Planning Application No: 3/2024/0312

Proposal: Proposed subdivision of first floor flat into two.

Location: High View, Humber Street, Longridge PR3 3WD

**PROPOSED GROUND FLOOR PLAN -
ILLUSTRATING PROPOSED CYCLE STORAGE**
Scale 1:50

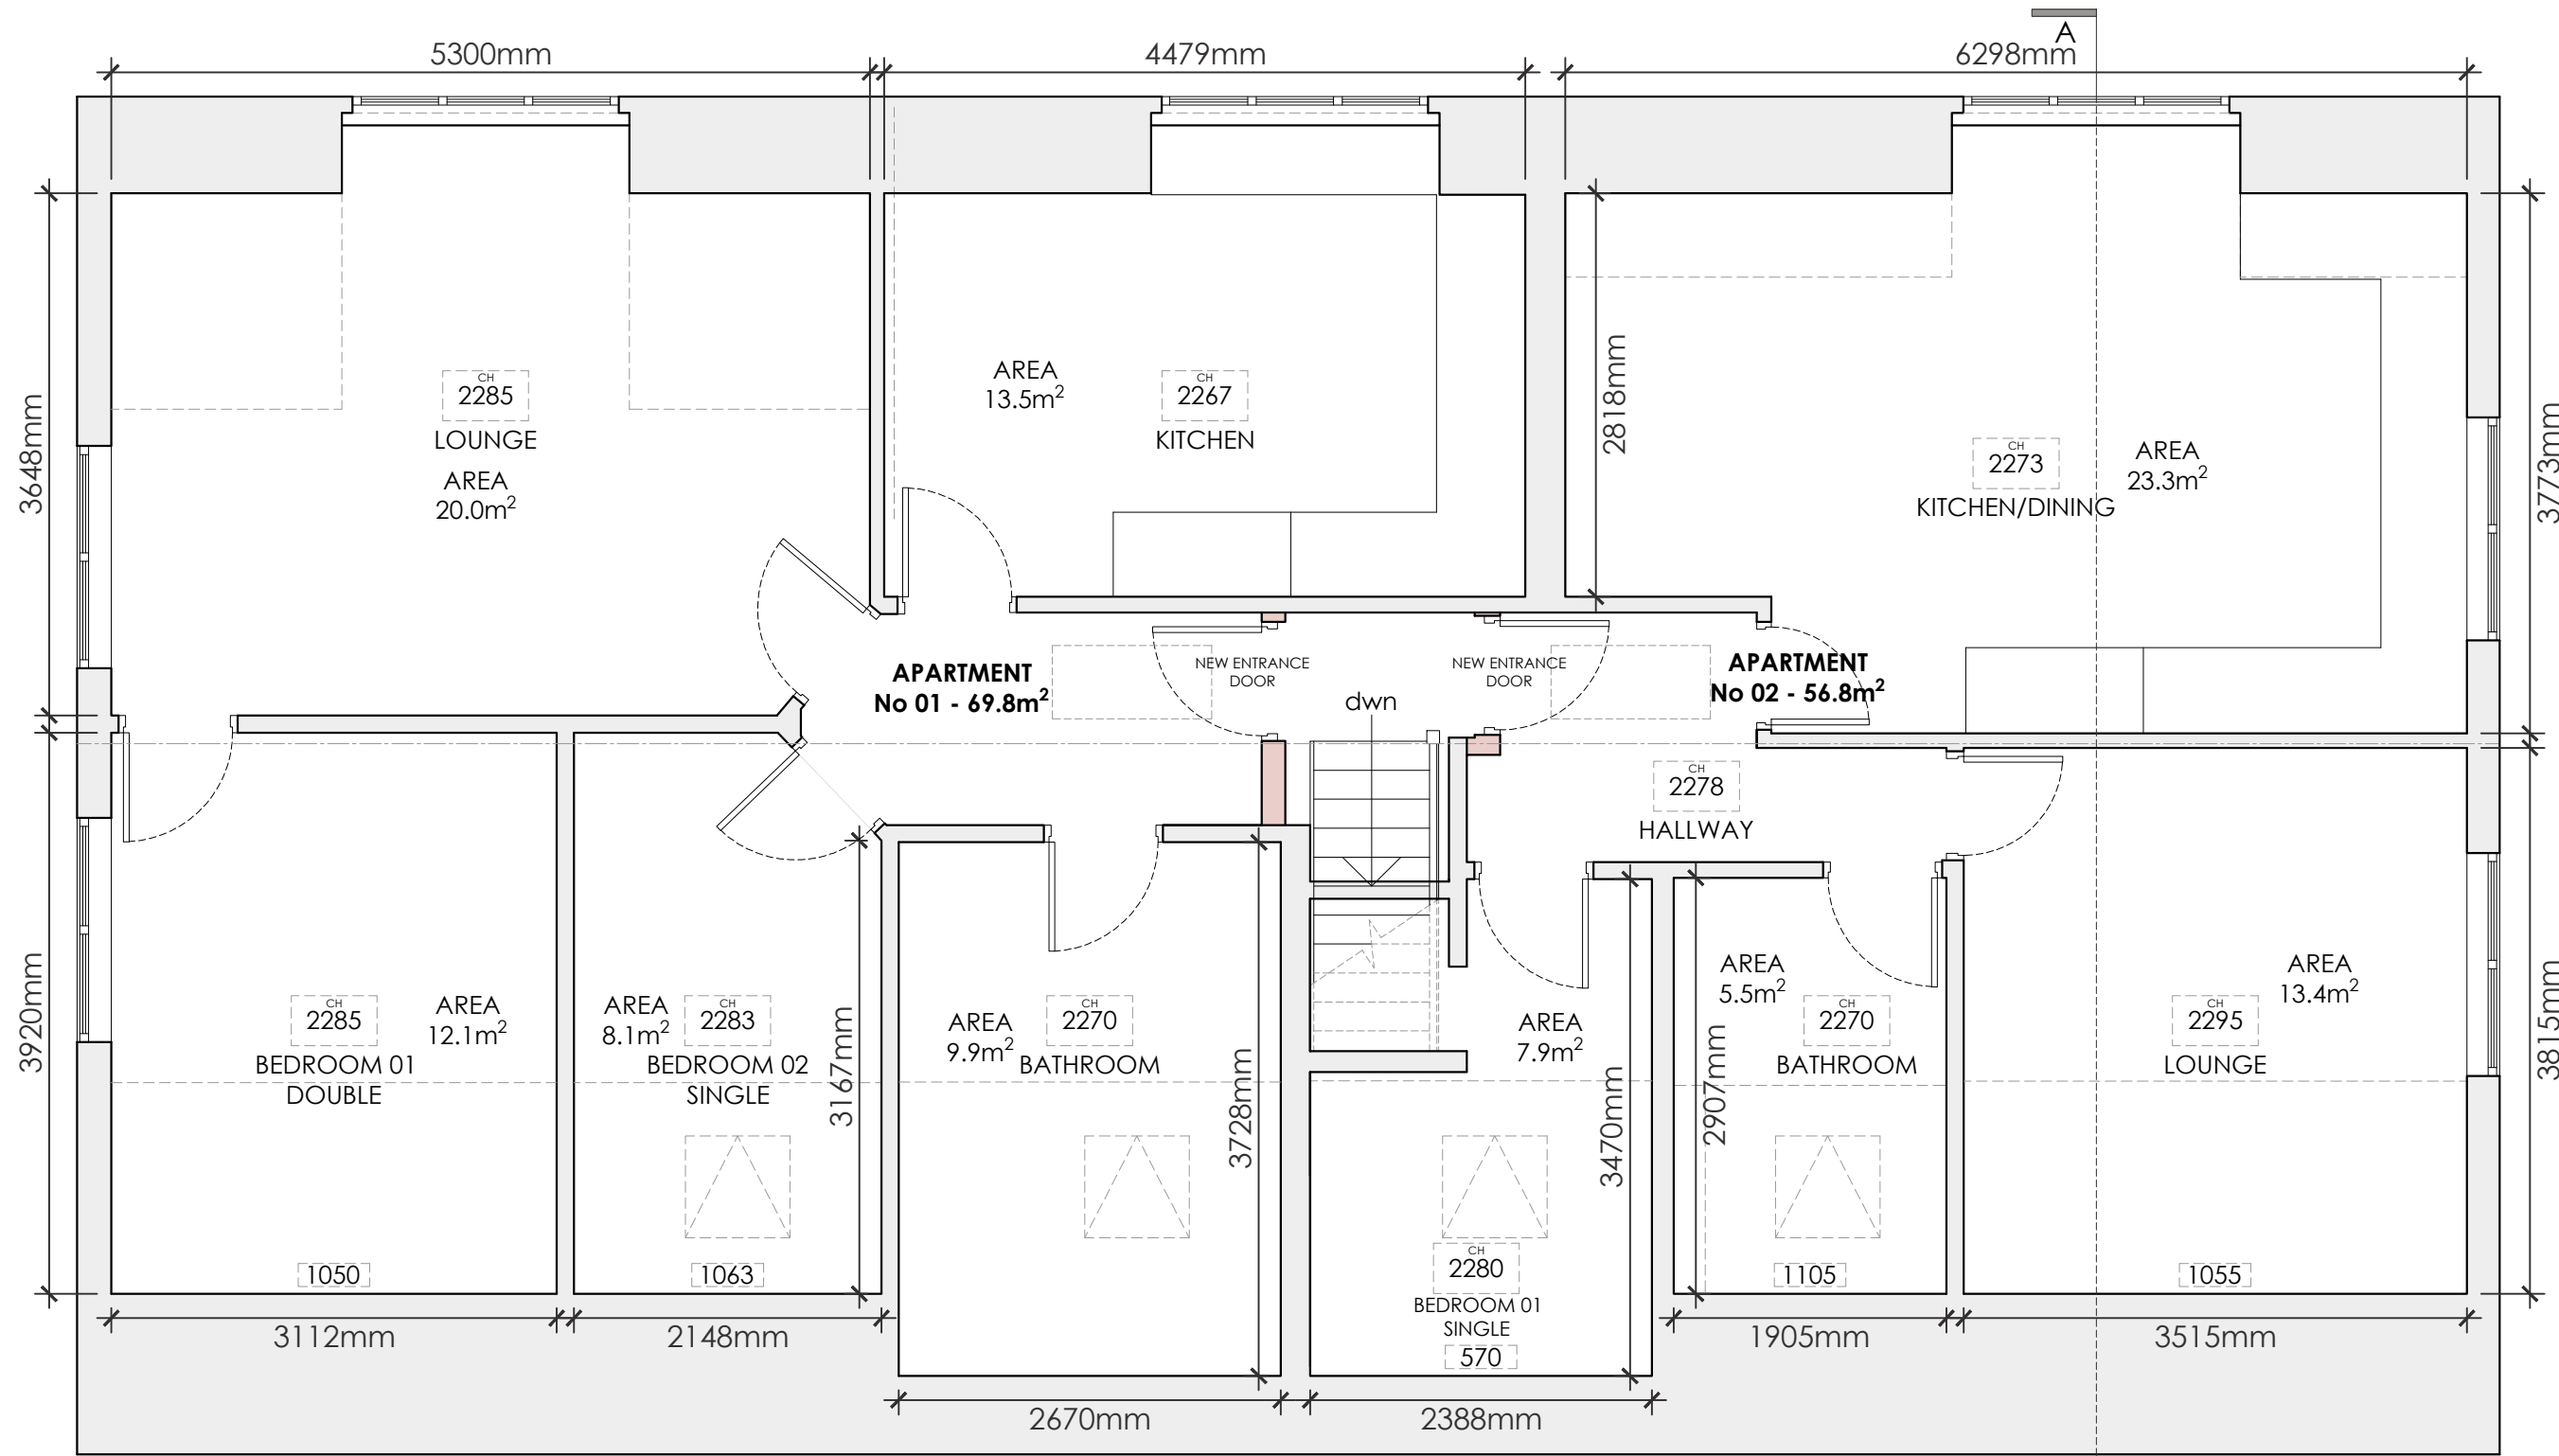
Storage for two cycles is proposed at ground floor level within the entrance hallway. Secure, covered storage, eg cycle lockers, should be provided as the flats will be occupied independently and the storage area is not within nor overlooked by the flats. Details can either be submitted prior to determination of this application or be controlled by condition.

3. Prior to first occupation of the approved development secure, covered cycle storage for at least two cycles shall be provided in accordance with a scheme to be approved by the Local Planning Authority and permanently maintained thereafter. Reason: To ensure that the development provides the infrastructure to support sustainable forms of transport.

PROPOSED SITE PLAN - ILLUSTRATING PROPOSED PARKING PROVISIONS AND REFUSE BIN AND RECYCLING COLLECTION POINTS.

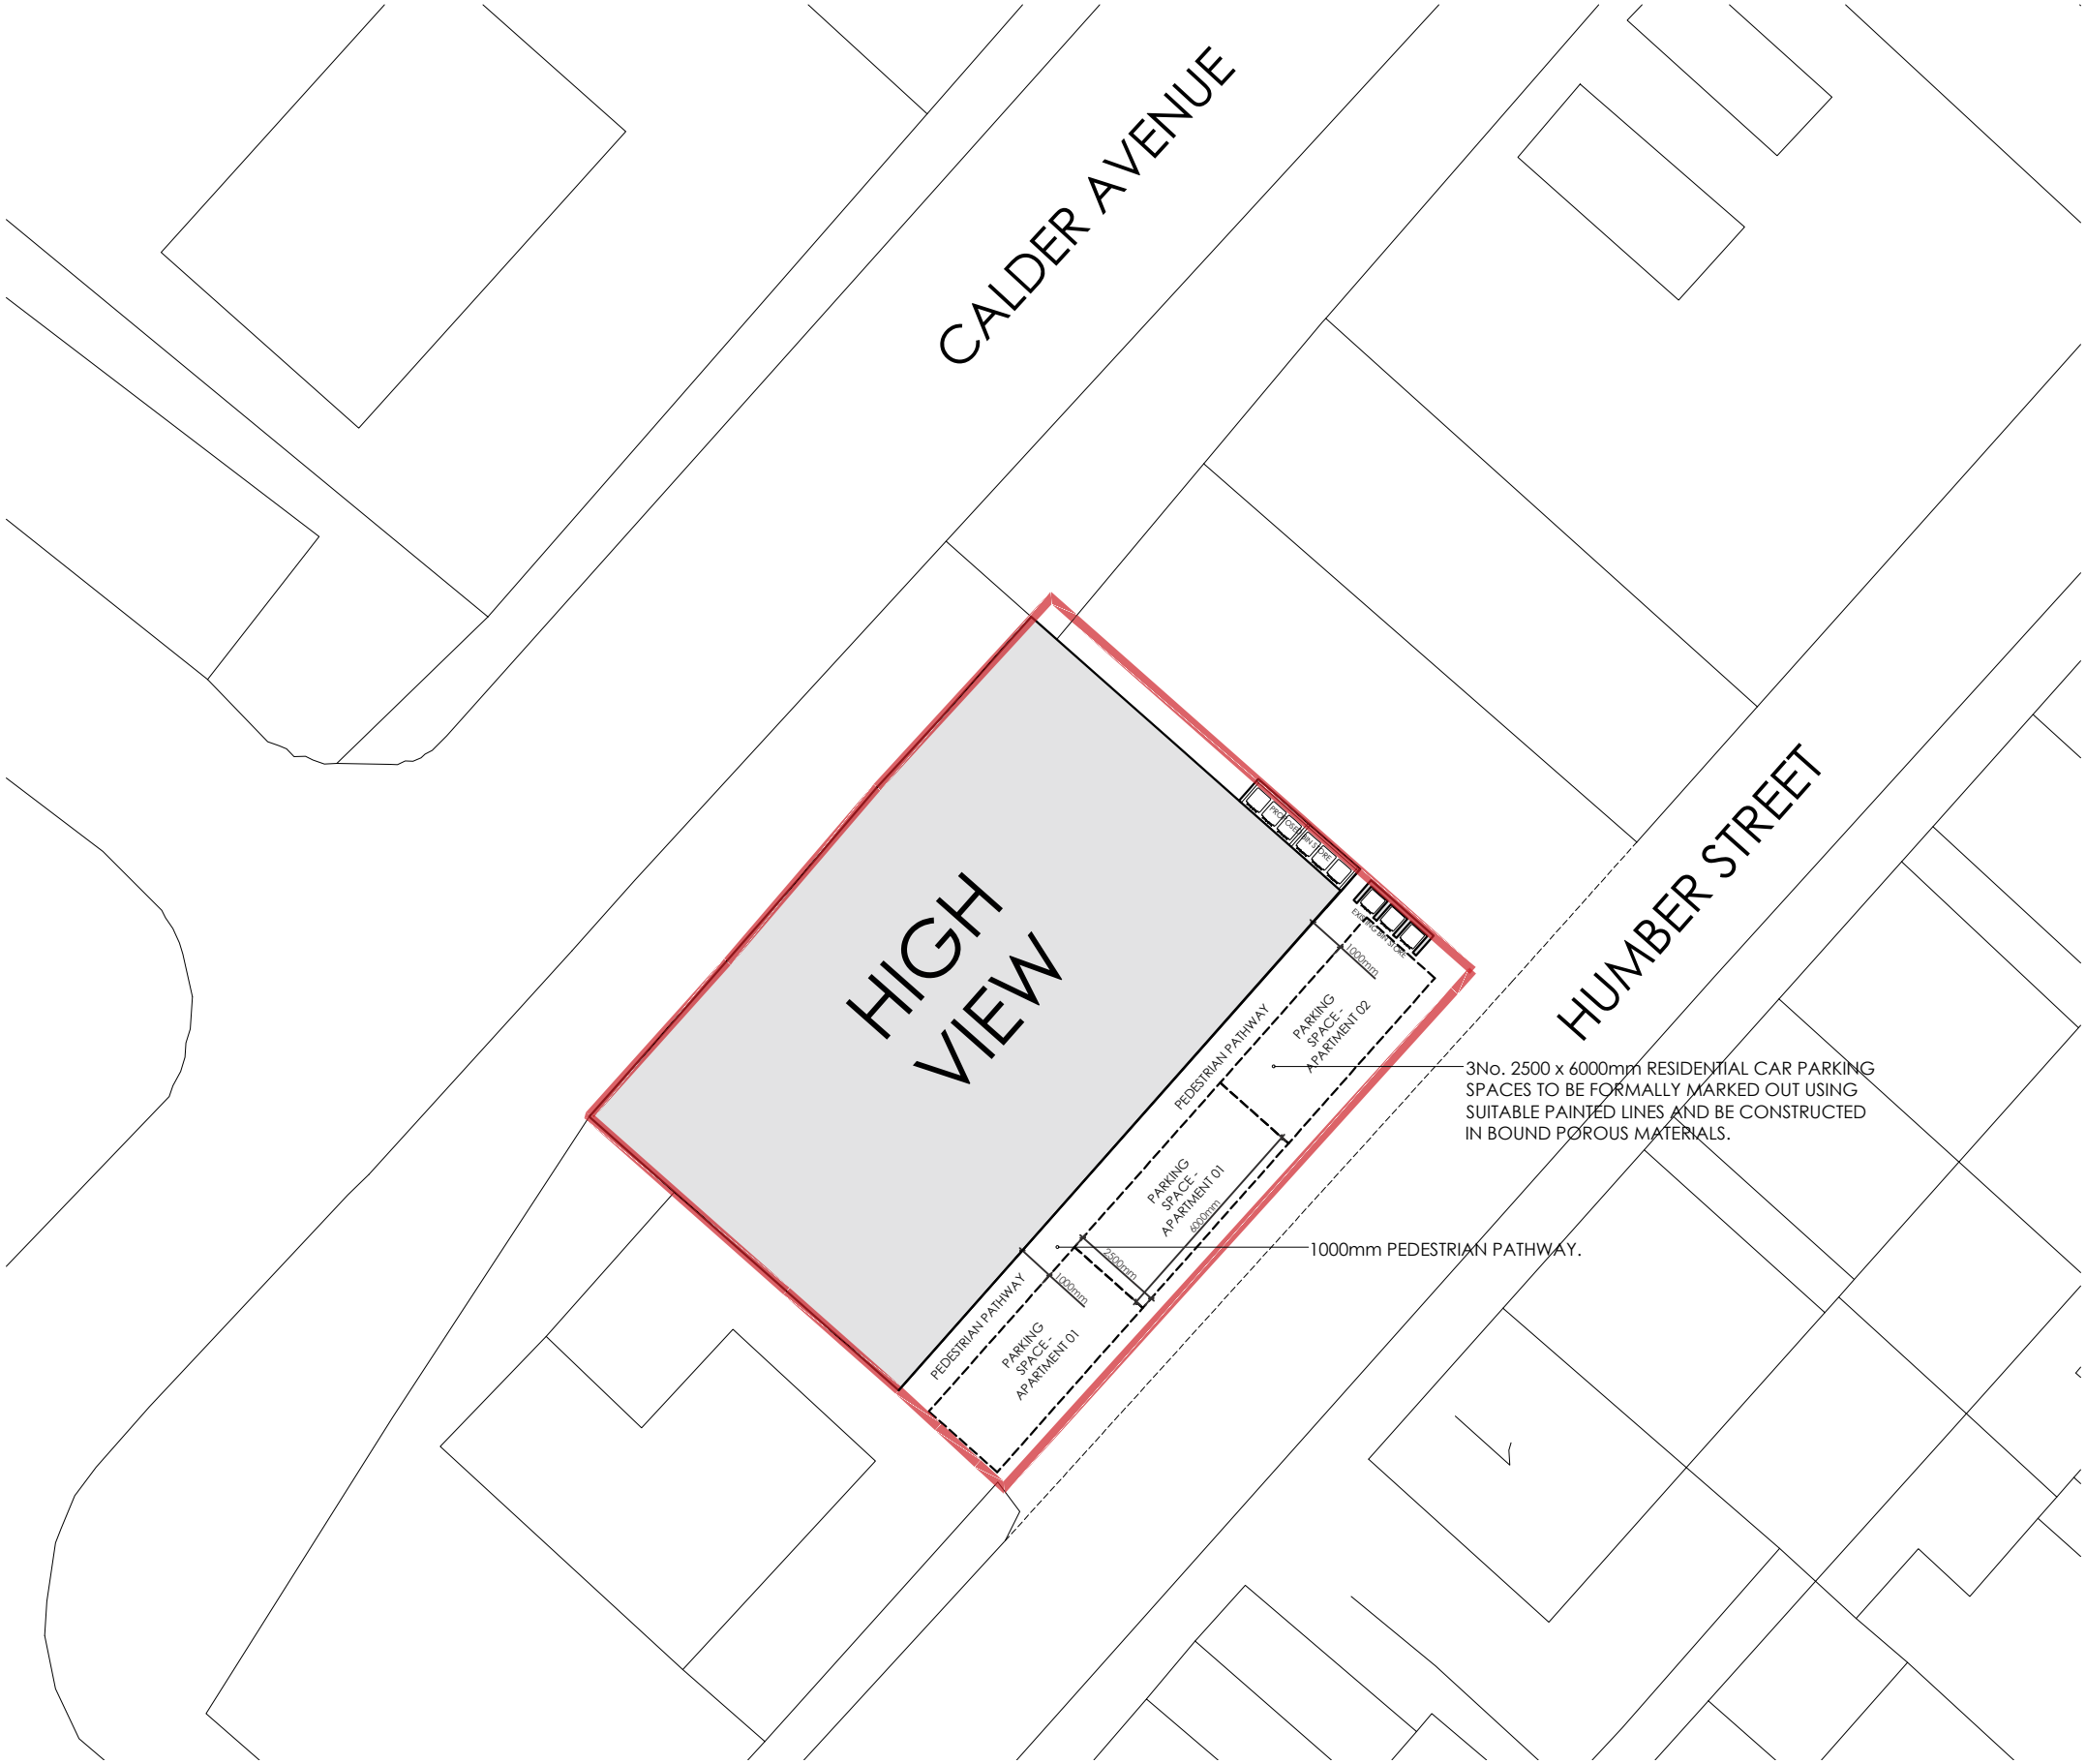
It has been noted that disabled parking for the existing ground floor businesses is currently provided on Humber Street as access to these businesses from Calder Avenue is via a flight of steps. Parking for the flats would remove this provision and vehicles parked here may also obstruct the rear pedestrian accesses to these businesses. To protect pedestrian access a pedestrian walkway at least 1m wide should be marked along the edge of the building.

Parallel parking bays should be at least 6m long to allow vehicles to manoeuvre to and from the bays. The three parking bays proposed should be formally marked out to ensure that access is maintained to all bays at all times. These should also be set back from the building to allow pedestrian access. The highway authority also recommends that the bays are allocated to each flat.

1. Prior to first occupation of the approved development the parking areas shown on the approved plans shall be constructed in bound porous materials and formally marked out. The parking areas shall thereafter always remain available for the parking of domestic vehicles associated with the dwellings. Reason: In order to ensure satisfactory levels of off-road parking are achieved within the site to prevent parking on the highway to the detriment of highway safety.

2. Prior to first occupation of the approved development a pedestrian walkway at least 1m wide shall be marked along the edge of the building facing Humber Street and maintained free from obstruction in perpetuity. Reason: In the interest of pedestrian safety.
